Permit Number: 050355

has permission to 26x36 Cape w/frostwall foundation

AT 3 Sandpiper Rd / Alderbrook

RE: 3 Sandpiper Road, Peaks Island, 085-M-008 – IR-1 Zone – application #05-0355

PROPOSED SINGLE FAMILY DWELLING
32 ALDERBROOK ROAD PEAKS ISLAND, MAINE

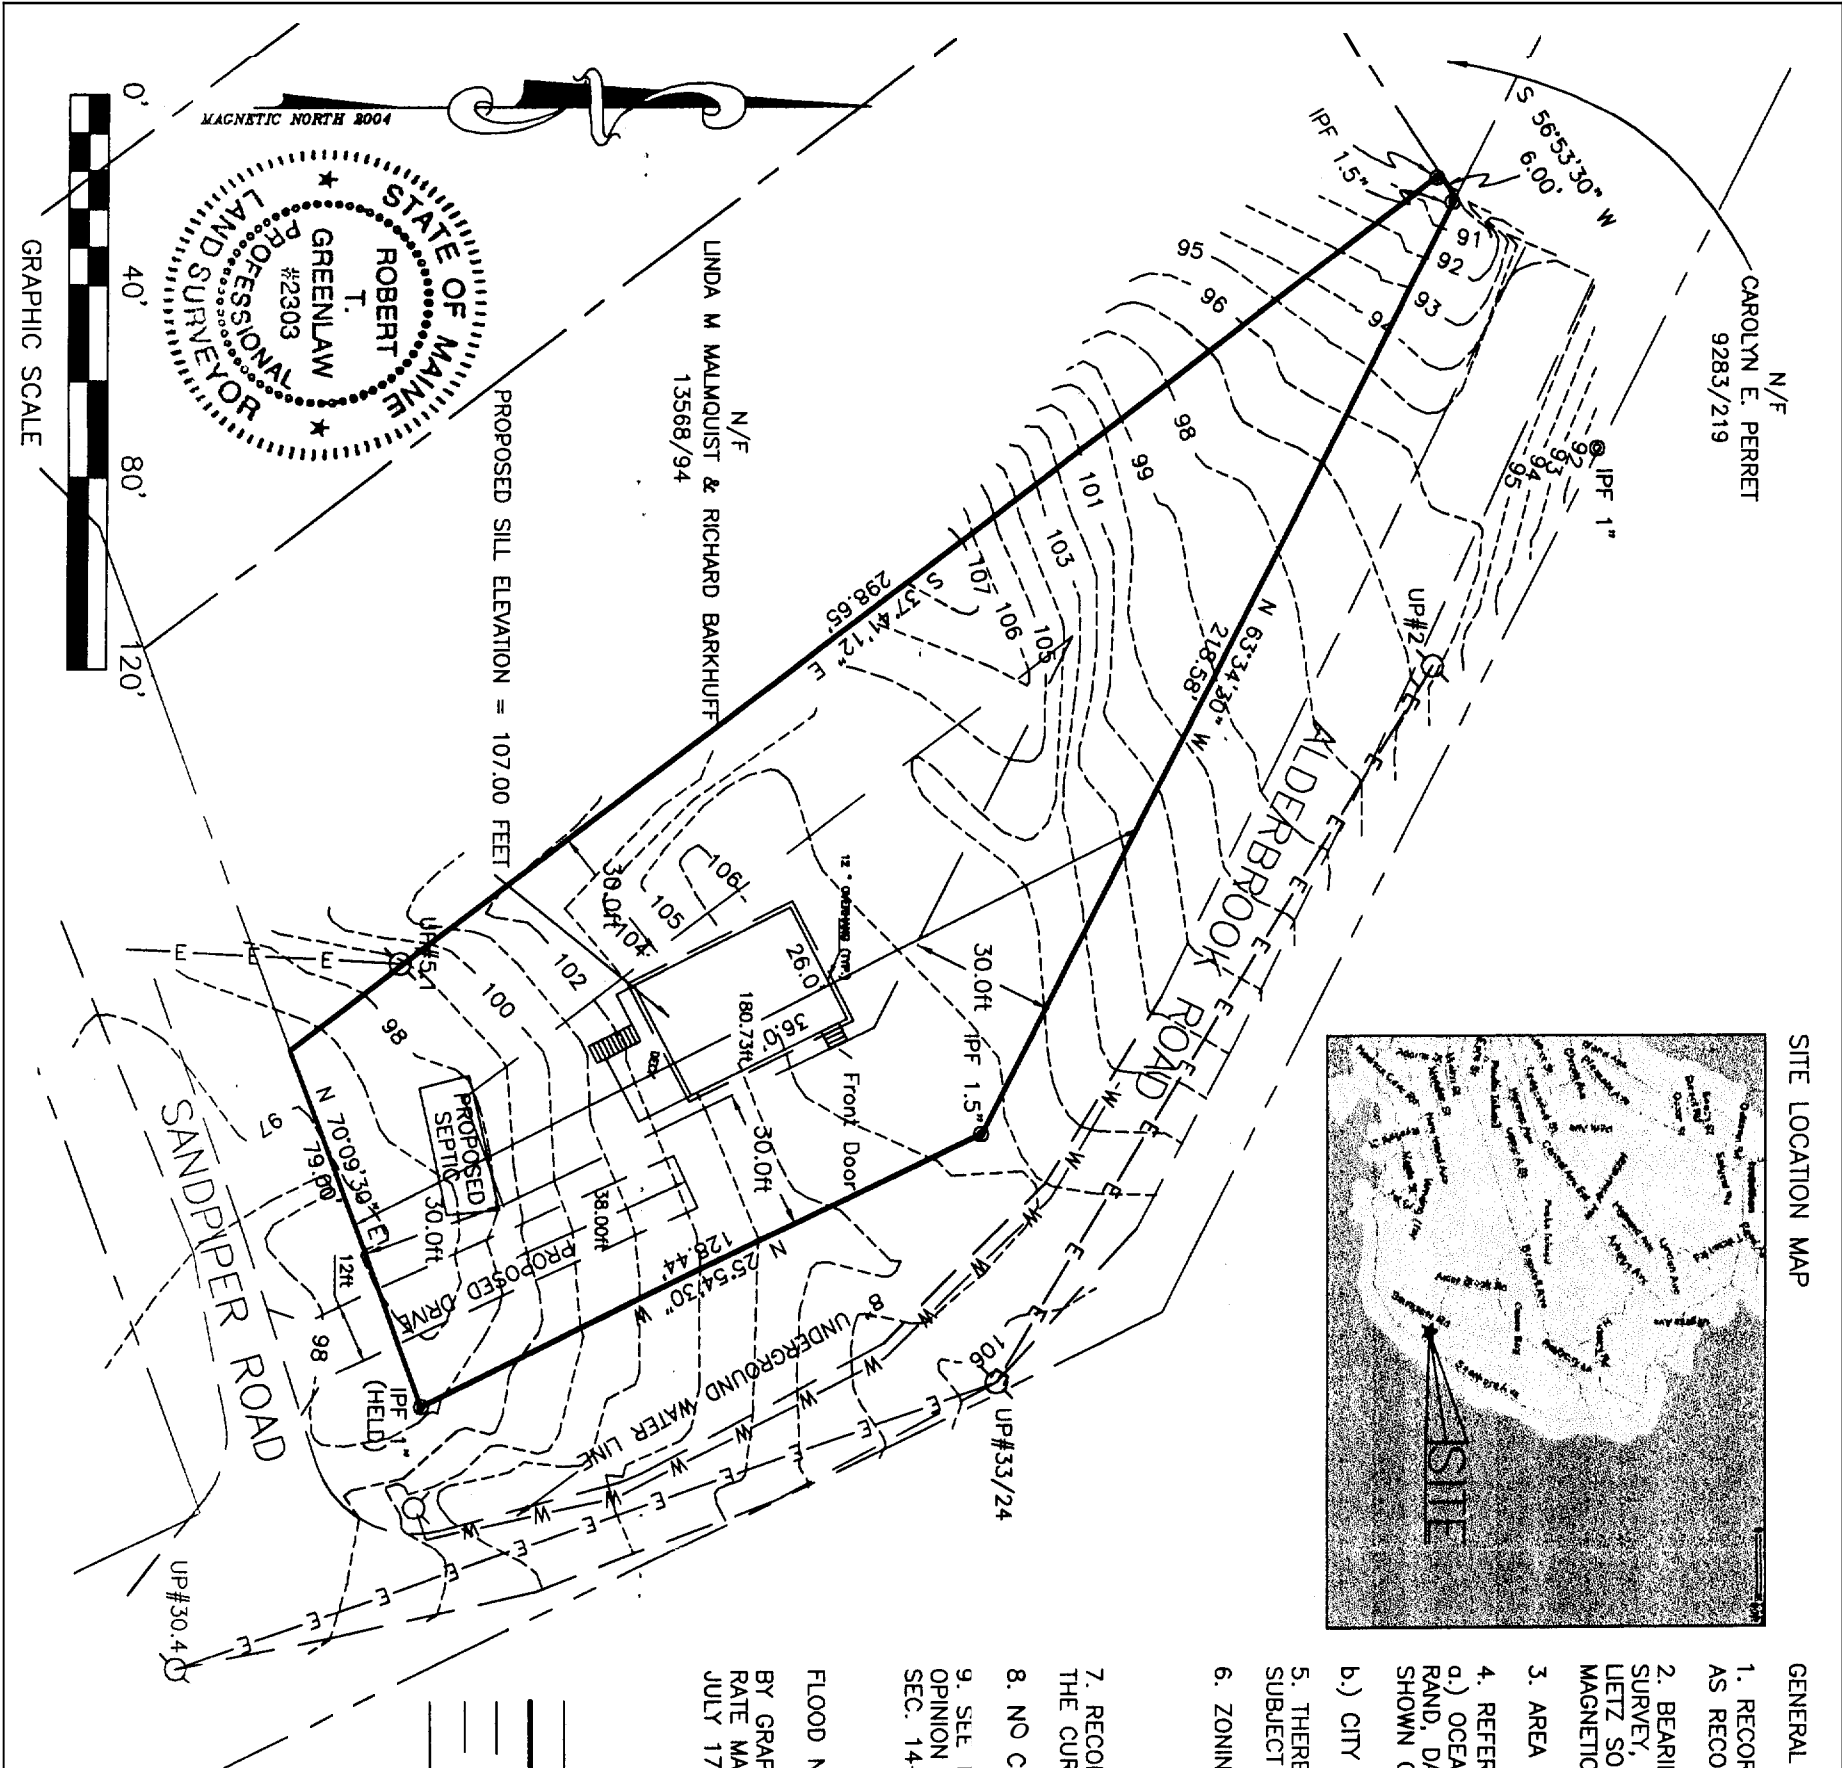
Your plan submittal shows the front yard building orientation to be abutting Sandpiper Road. Section 14-145.5(e) states that the minimum lot width thru the principal structure shall be a minimum of 100 feet from side yard to side yard. Your submittal is showing 93' at the narrowest point.

I am also unable to measure compliance with the maximum building height. On the islands, it is required to show pre-development grades and post development grades. It is required to measure building heights at the pre-development grade. No such grades were provided as part of your submittal package.

*re-orientated*

*NO photo on 5/14/05*

DRAWING: **TRUSS DIAGRAM**

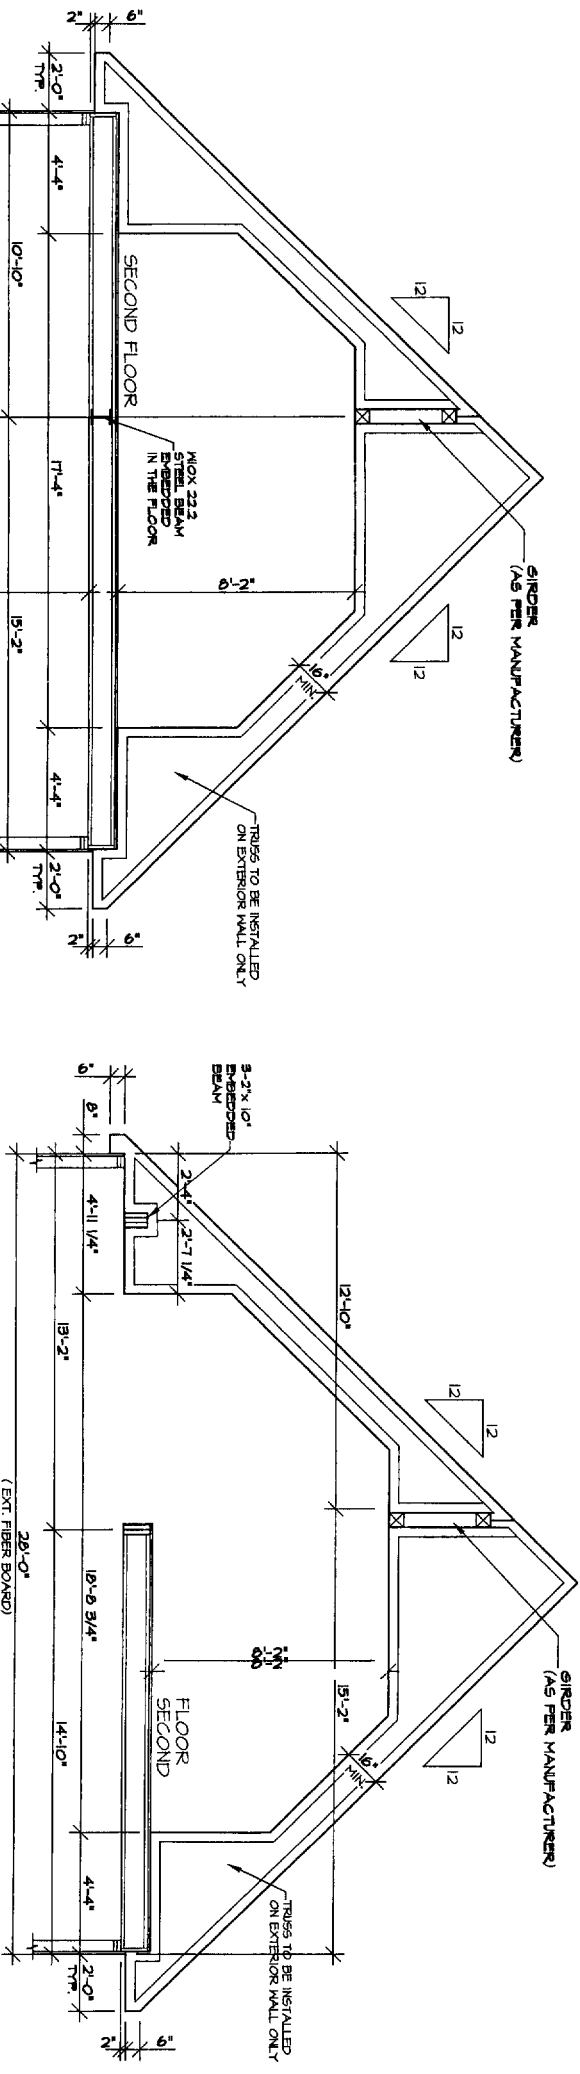
Framing For Screen Panel Roof  
Sheet # 8-10 Section  $\frac{4}{7/8}$

PROPOSED SINGLE FAMILY DWELLING
32 ALDERBROOK ROAD PEAKS ISLAND, MAINE

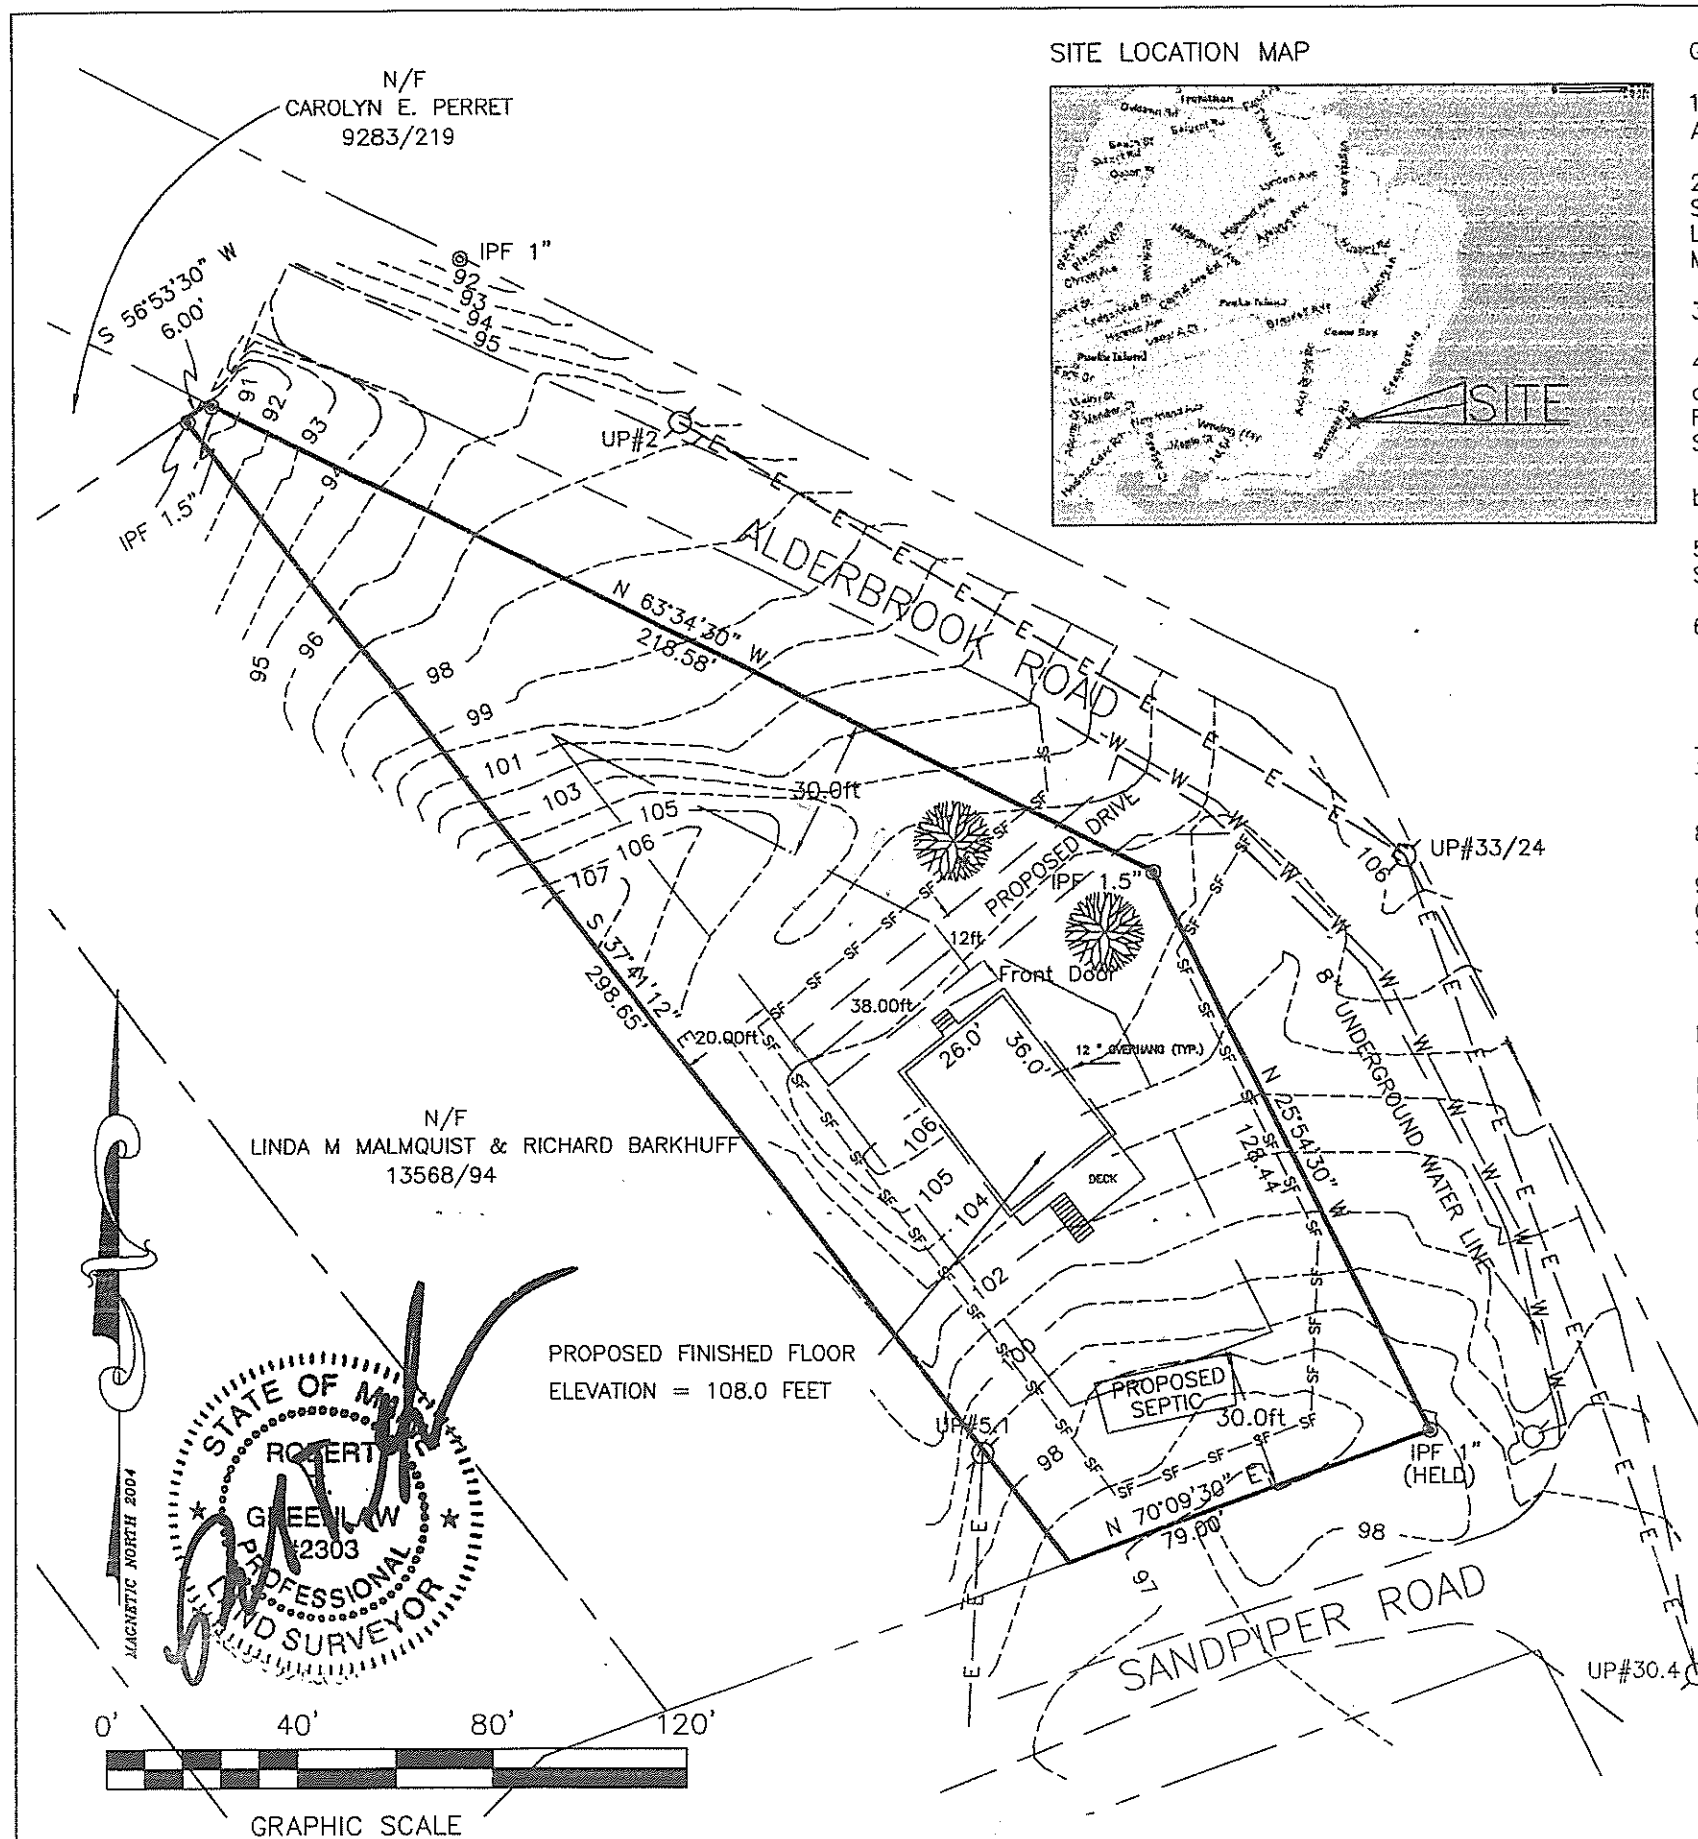
5/25/05 received info on chain of title &amp; reorientation of the bldg. Nothing on pre &amp; post grades. Reoriented the bldg toward Alderbrook Rd.

6/21/05 met with Arthur Harmon with a new house placement that pleases both of us.
